For the attention of Mrs A. Gardner
Reference : PLANNING APPLICATION No. A/136/14/PL

Dear Sir/Madam,
*Proposed erection of two four bedroom detached houses with garages,
Merrivale, Station Road, Angmering. Revised plan.*

SITE PLAN 1 : 500

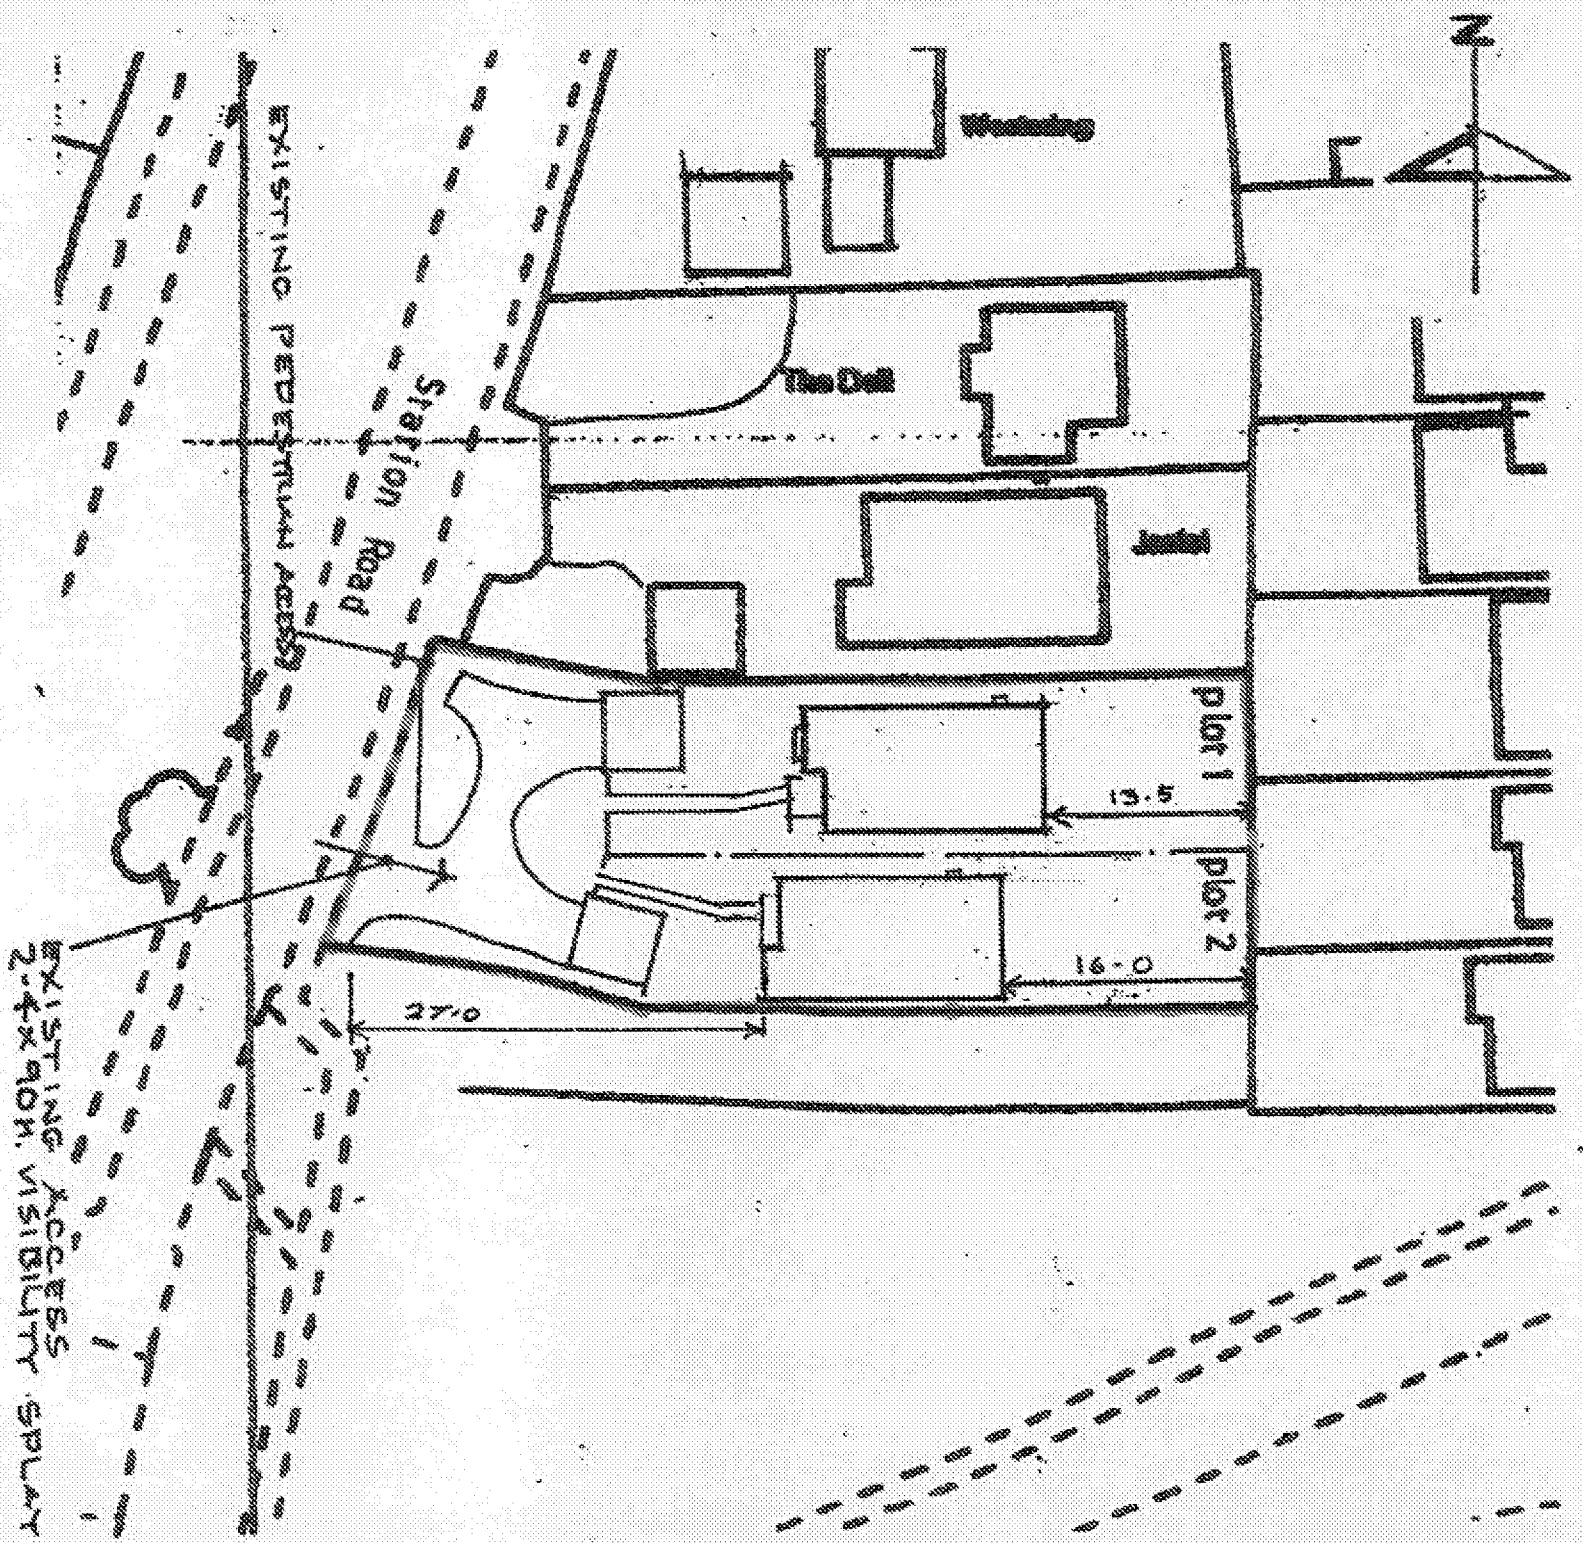
- 2) The small cosmetic adjustments made of a few centimeters in the new plan merely move one of the properties even closer to the site boundary on both sides which fails to address the fact that the plot width for 2 properties remains significantly narrower than others fronting Station Road.

FRONT ELEVATION [WEST]

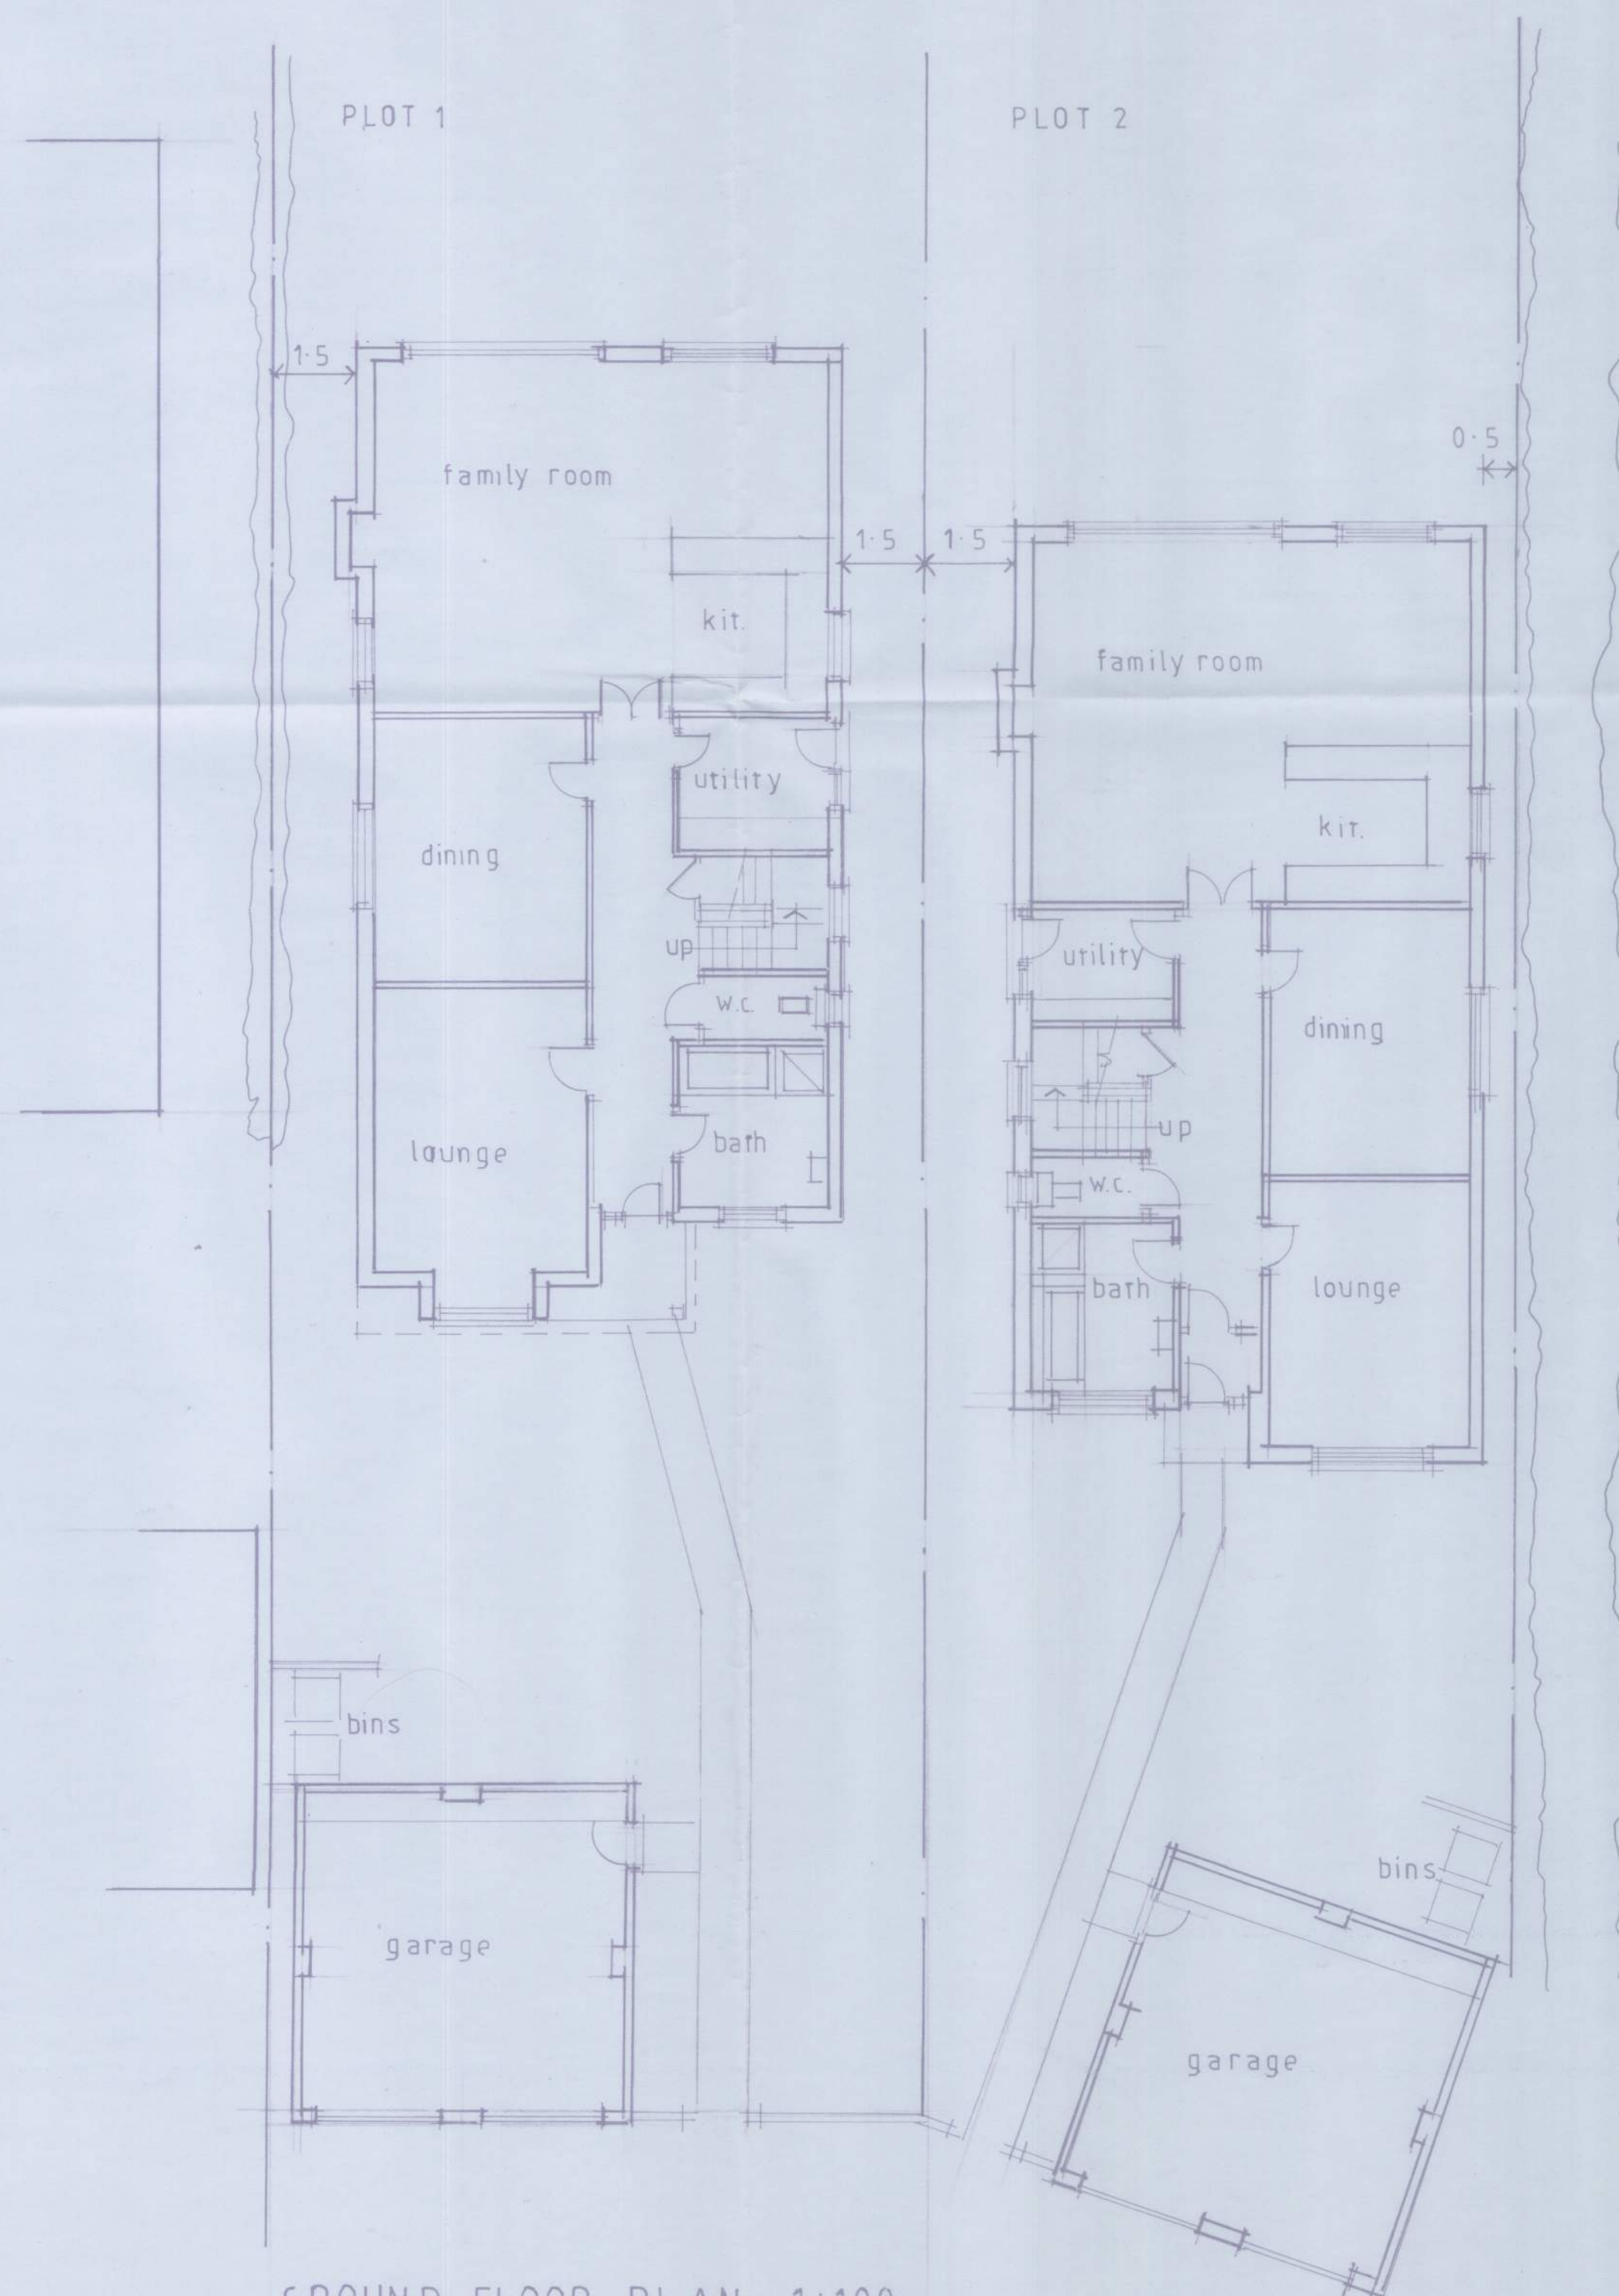
- 1) In rejecting the previous application the planning committee report stated that 'the plot width remains a concern'. This new application fails to address this fundamental issue by again proposing x2 two storey height dwellings in a cramped development which is 'out of keeping in the street scene' and 'would not replicate any of the design fronts of adjoining properties.'

- 3) The situation remains that these tall and elongated shaped properties would leave a 'significant footprint' and this 'proposal which would adversely affect the visual amenities of the locality' merely for the benefit of property speculation.
